Subject: Y/15/21/DOC Yapton - 38 units

Please find below also detailed responses to your queries raised in your e-mail dated 9th of March to 'Planning responses' and Simon Davis – copy of which is attached to this email. For ease of cross-referencing I have kept the same numbering as per your e-mail with all other points considered to be closed now.

Scale	Date	Designed
AS SHOWN	JUL 20	CJL
Drawn	Checked	Approved
CJL	SW	JHM
Job No	Drawing No	Rev
18-204	YAP-180-031	T3

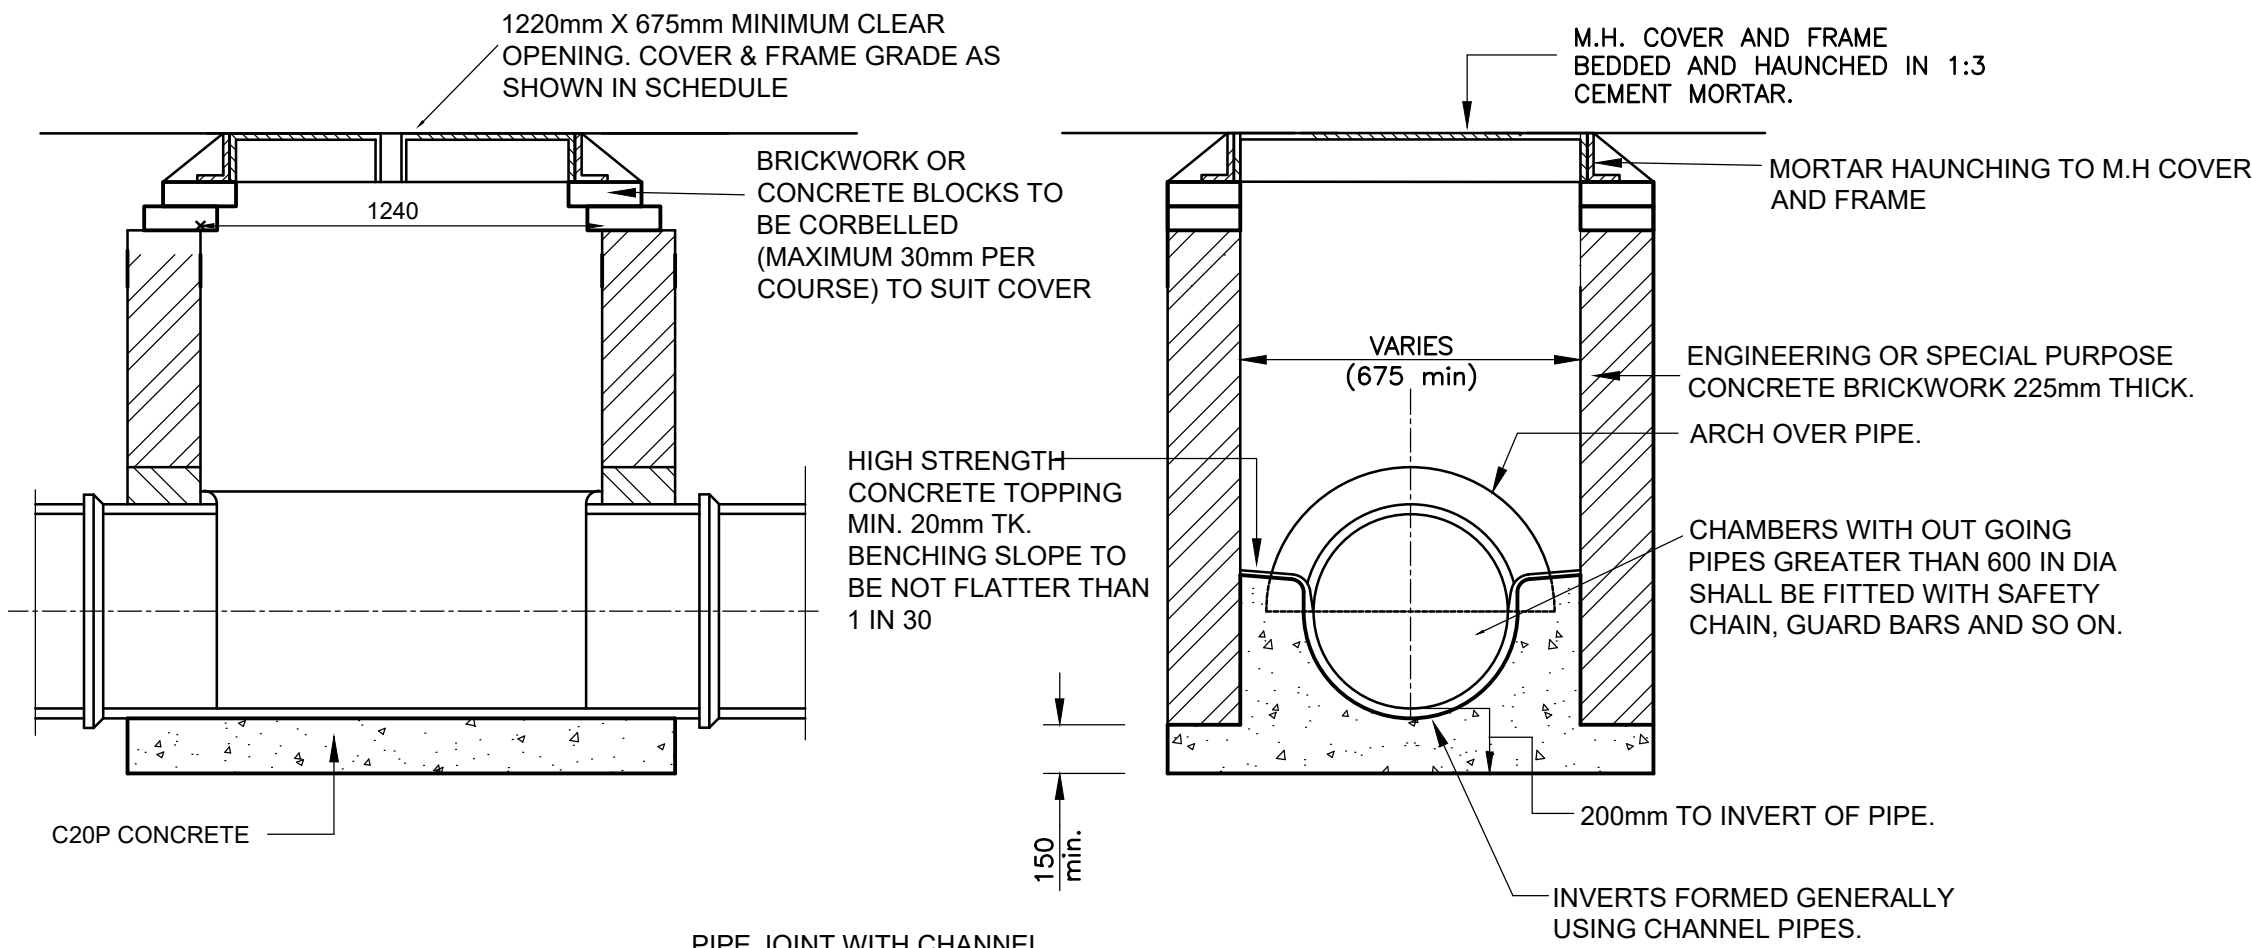
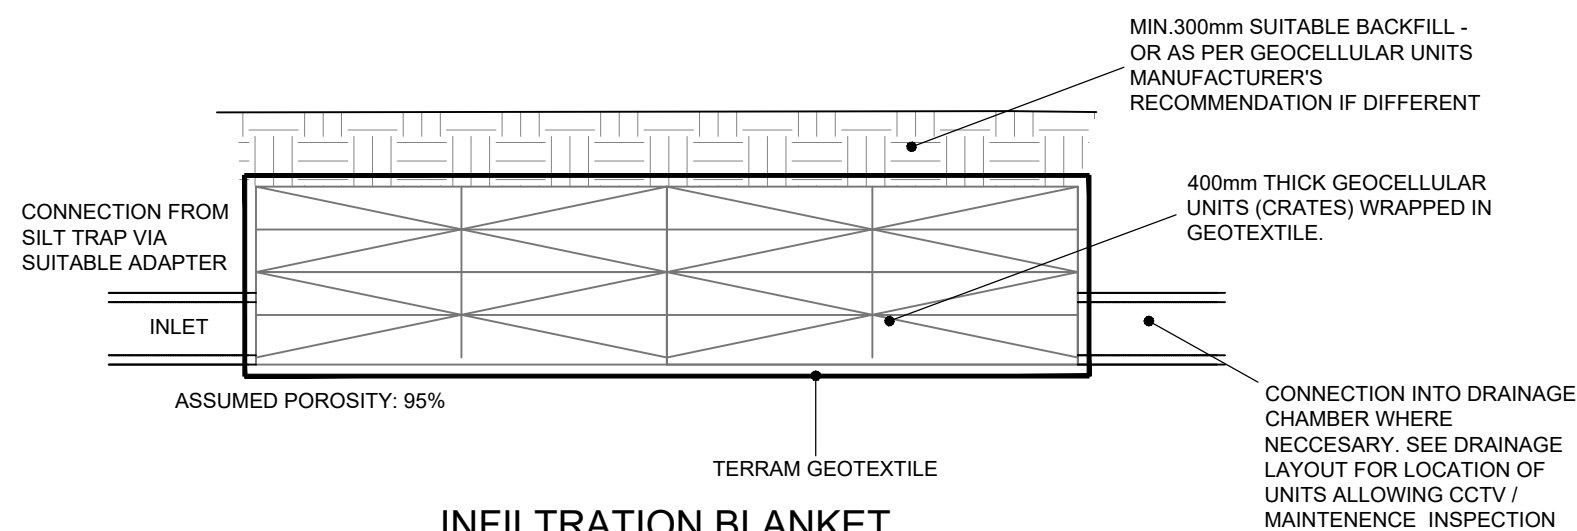
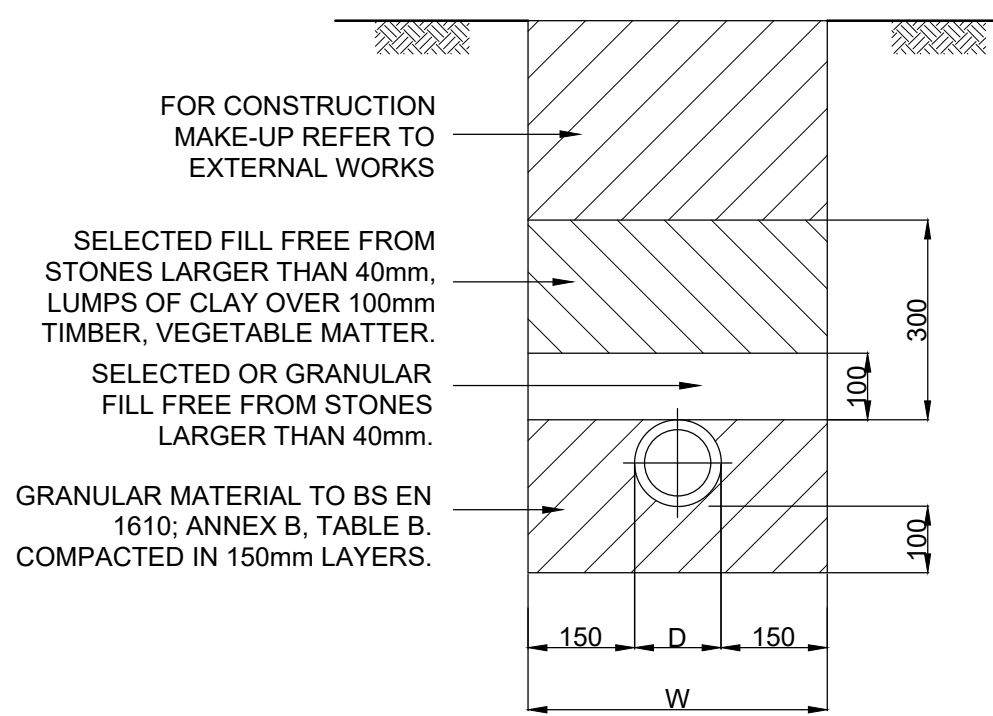
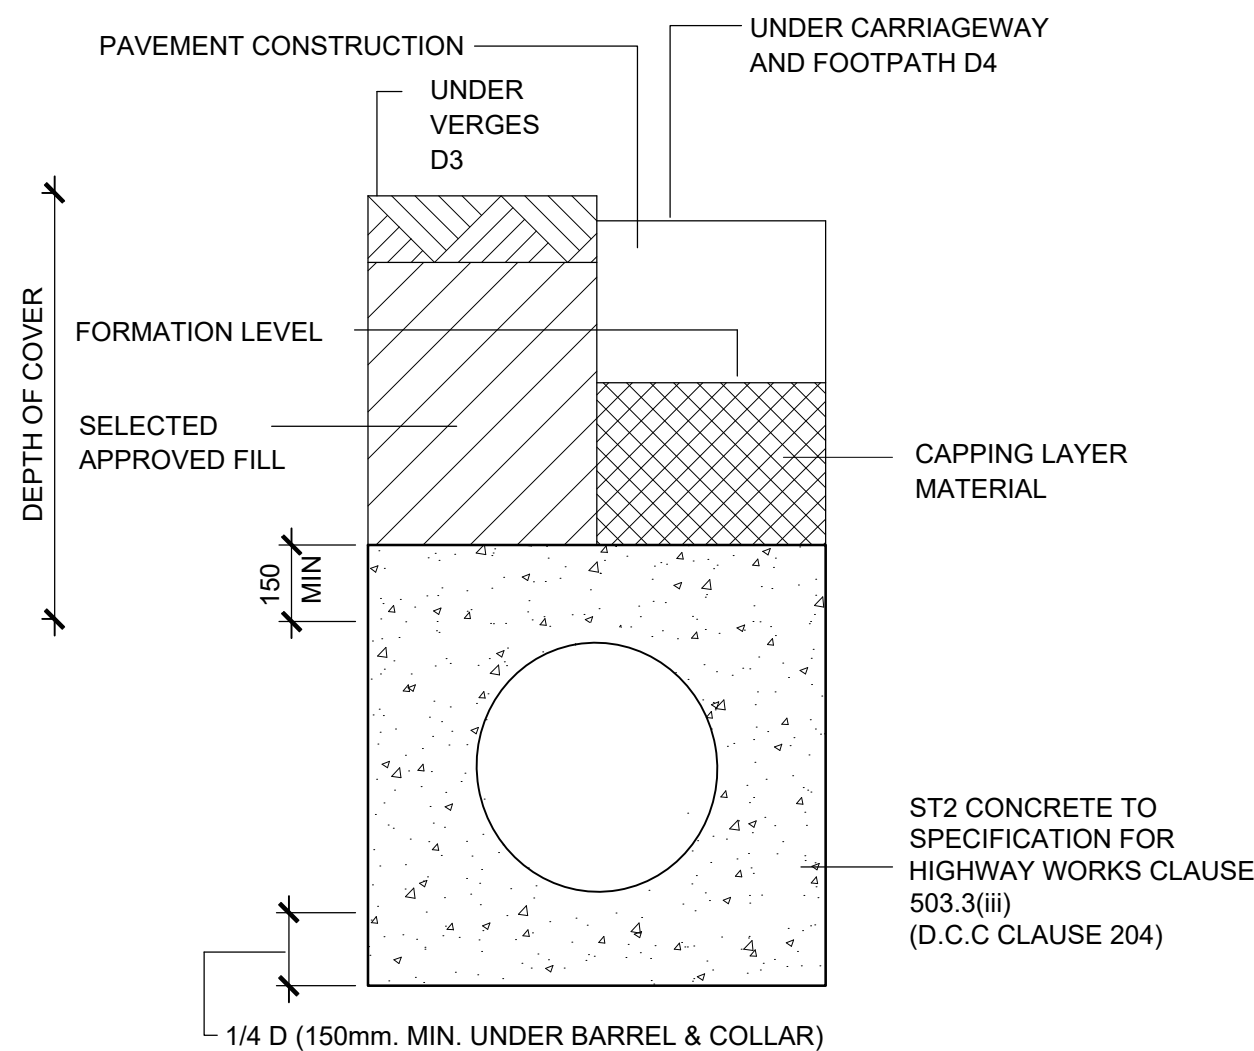
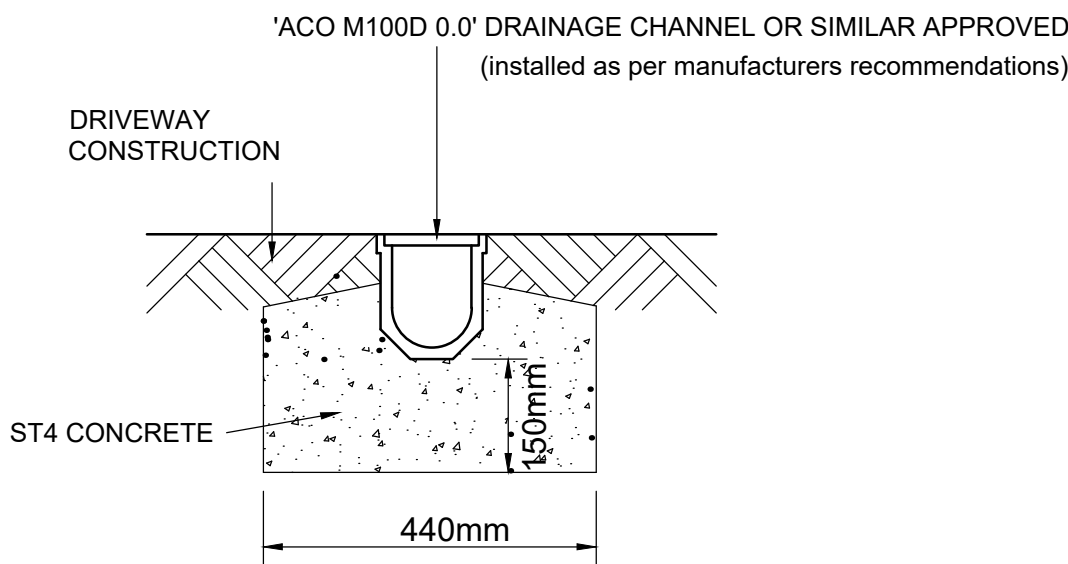
11. Alteration to the design undertaken. To comply with the LLFA SuDS Policy 1 point 5.2.2 the surface water (SW) system is designed so the last SW chamber (silt trap) is above the 1 in 10 years plus cc water level within permeable paving system. SW system chambers for Road 2 are not therefore lower than 5.995m AOD, which is a water depth of 0.15m (please see Road 2 with plots 23,25-28_1 in 10 yrs with CC_Rev_B calculations) for the storm design event added to the permeable paving base level of 5.835m AOD. The same principle will apply to Road 3, in this instance the water depth for the 1 in 10 yrs plus cc event is 0.288m (please see Road 3 plus plots 29-32_1 in 10 yrs with CC_Rev_C calculations) and with permeable paving sub-base level of 5.430m AOD (measured at the downstream end of Road 3, please see drawing YAP-130-028C1) results in the design water level of 5.718m AOD. We have designed last SW chamber (silt trap) prior to Permavoid connection to be not lower than this level and downstream pipe do not have any additional connection thus serves as connection conduit only with the actual SW system not being subjected to surcharge during the 1 in 10 yrs plus cc event. However, due to the use of proprietary connection fittings it is required to make connection directly to the Permavoid units, i.e. at the base of permeable paving - please see drawings YAP-130-082C3 and YAP-180-031C2.

**INFILTRATION BLANKET
(GEOCELLULAR UNITS - CRATES - CONSTRUCTION)**

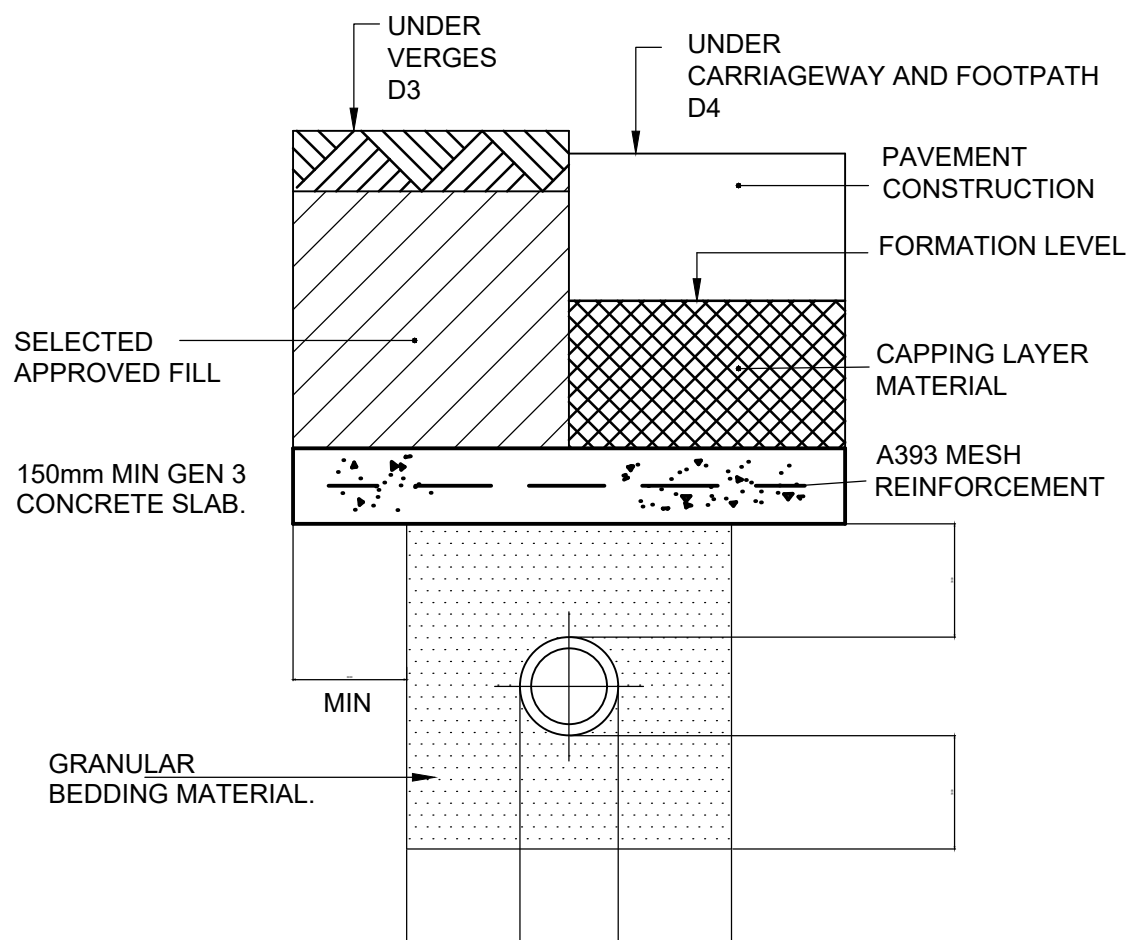
3. Cover thickness above geocellular infiltration blanket in the public open space increased to 0.5m. Please note that it was envisaged that maintenance contract would specify the use of grass trimmers only rather than ride on mowers – this is now considered as not relevant. With regards to protection from construction traffic, the POS area above the infiltration blanket is to be kept clear during construction and the site compound was previously relocated to accommodate this requirement, please refer to the 'YAP-CMP-01-F Construction Environmental Management Plan (CMP)' drawing.
The crates in the back garden will be free from loading as any material deliveries for the substructure and superstructure works are delivered via forklift on a loading bay at the front of the plots. We have also notes on drawings TL which is top of the blanket and CL which is the minimum ground level above blankets.

Job Title			
LAND AT STAKERS FARM, YAPTON			
Drawing Title			
HIGHWAY CONSTRUCTION DETAILS (SHEET 1 OF 2)			
Client			
DANDARA LIMITED (SOUTHERN)			
Scale	Date	Designed	
AS SHOWN @A1	SEP 2020	AK	
Drawn	Checked	Approved	
JK	AK	SW	
Job No	Drawing No	Rev	
19-156	YAP-180-035	T4

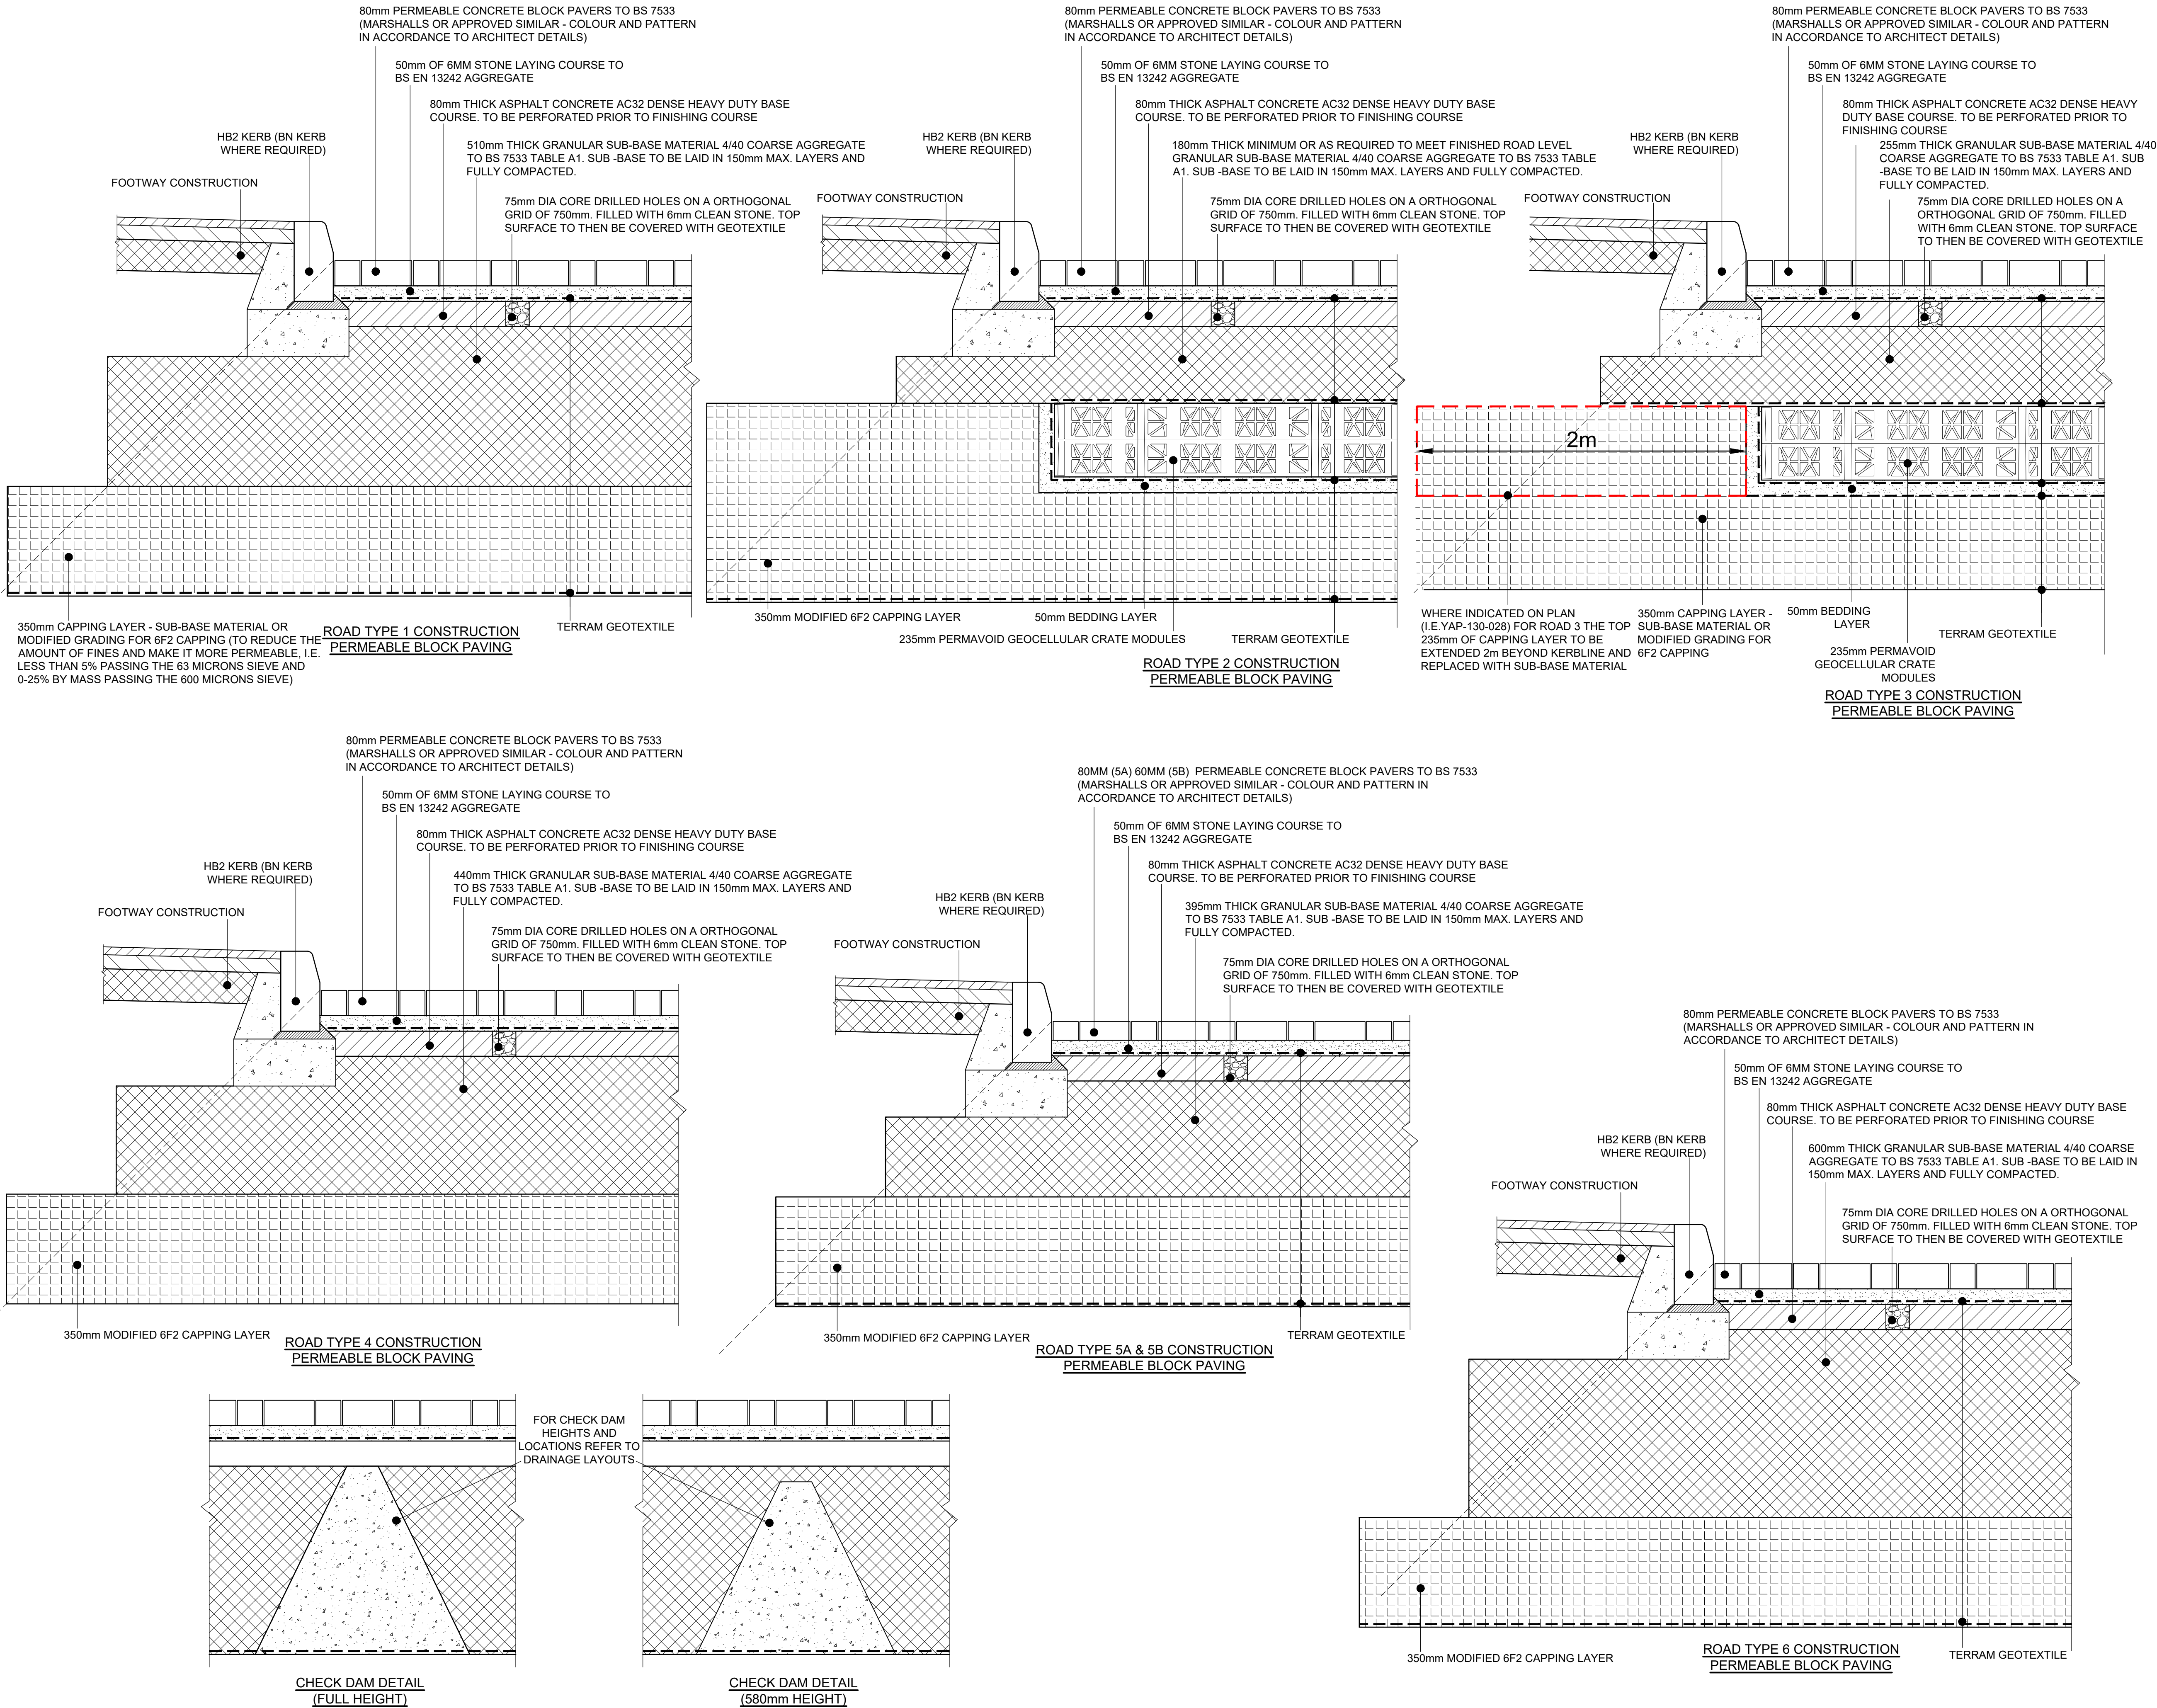
14. Sewerage undertaker satisfied with the proposals – please refer to the S104 compliance letter.
15. Road 3 will have increased sub-base material (as per construction detail for Road 3 on drawing YAP-180-035C2 Highway Construction Details Sheet 1 of 2) that will extend 2m beyond kerbline as indicated by hatched area on the YAP-130-028C1 Pervious System Network Layout_38 Units drawing. This is modelled as additional permeable paving sub-base at the same level as Permavoid crates (and is added to help with the half-drain times), with the actual pavement sub-base modelled on top of Permavoid. Additionally external works layout drawing YAP-150-071C1 and Pervious system network drawing YAP-130-028C1 clearly identify road type construction areas.
